Officers Report

RE: Replacement dwellinghouse
SITE: 29 Parkfield Road Ickenham

Plan Numbers: PA-01 - received 26 Jan 2021

SITE PLAN
1:500

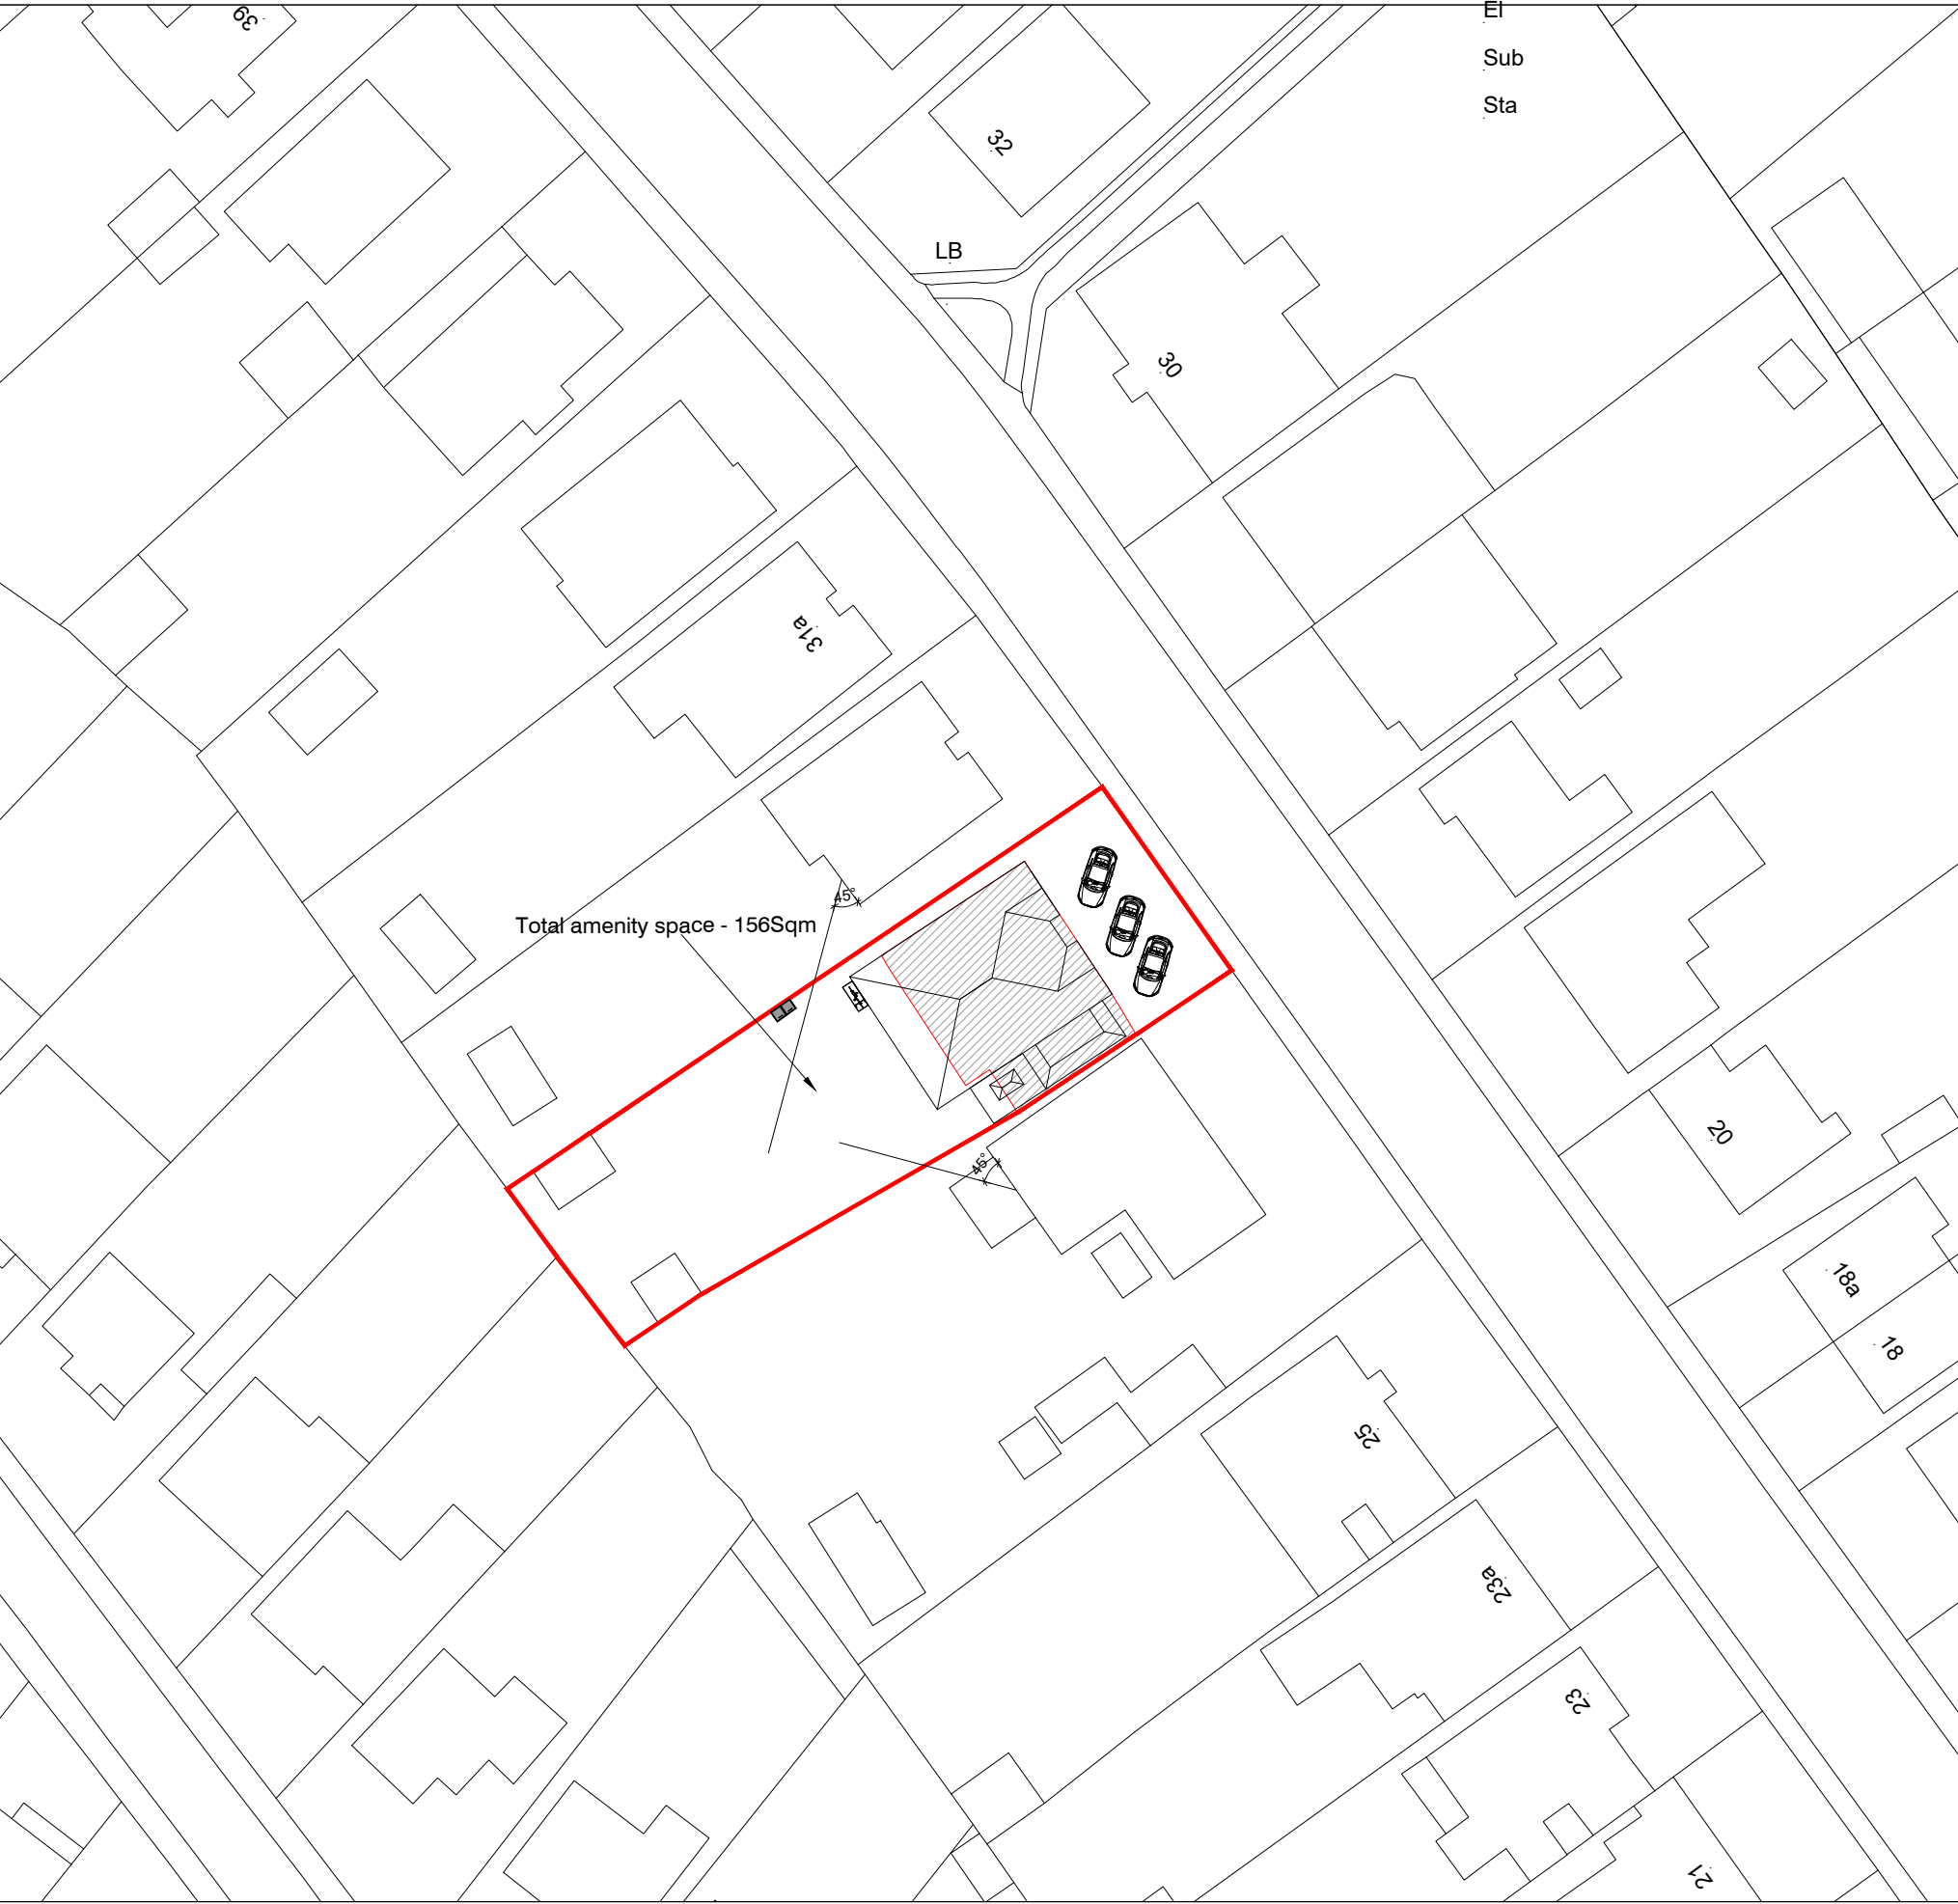
The proposed site plan identifies that the proposed dwelling would mostly be positioned between the flank walls of the neighbouring properties, projecting approximately 3.4m to the rear of no. 31 and set back approximately 3.9m and projecting less than the neighbouring conservatory at no. 27. The plans also indicate that the proposal would not contravene a 45 degree line of sight from the rear windows of these properties. As such it is not considered that the proposal would result in an un-neighbourly form of development with regard to overbearing or loss of outlook. The proposed windows for the principle rooms would face front and rear, with the two first floor side facing windows serving non habitable rooms. Any submission should ensure that these windows could be conditioned as obscure glazed and non opening below 1.8m.

PROPOSED FRONT ELEVATION
1:100

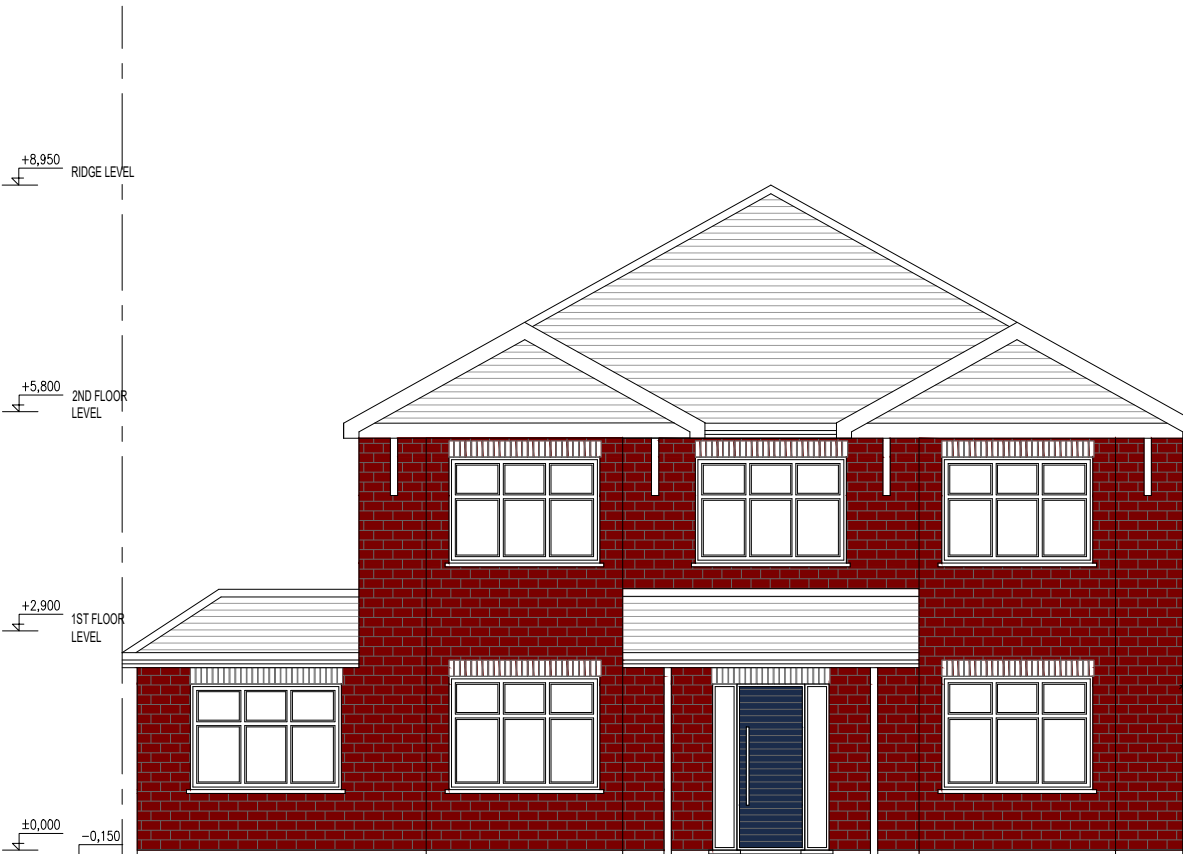
The proposed dwelling has a maximum depth of 14.35m including a two front bay projections and 14m in width, including an attached single storey side element of 3.1m in width and is set beneath a hipped roof of 8.9m in height. The proposal maintains the established front building line and would be set back 1m from the shared side boundary with no. 31, with the single storey element extending up to the

The existing street scene is a mixture of bungalows and two storey properties and therefore the replacement of the existing bungalow with a two storey property is not in itself out of place. The proposal would increase the footprint of the original property by approximately 1.35m to the rear and maintain gap views between the properties, with the set back from the side boundary with no. 31 and the single storey element adjacent to no. 27, reducing the bulk of the property on that boundary, when compared to the existing bungalow. The inclusion of two storey bay features to the front, are also a characteristic to be seen on other two storey properties within the street scene. However whilst there is no objection in principle to the replacement of the dwelling, it is noted that the height at 8.95m would be significantly higher than any other within the street scene, which are typically no more than 8m, with the maximum of 8.55m on a property further along the road. Consideration should be given to reduce the height in line with the general character of the wider area.

Whilst there is no objection in principle to the replacement of the existing bungalow with a two storey dwelling, there is concern over the proposed height of the proposed dwelling. It would be significantly higher than any other within the street scene, which are typically no more than approximately 8m, with the maximum of approximately 8.55m on a property further along the road. Consideration should be given to reducing the height in line with the general character of the wider area.
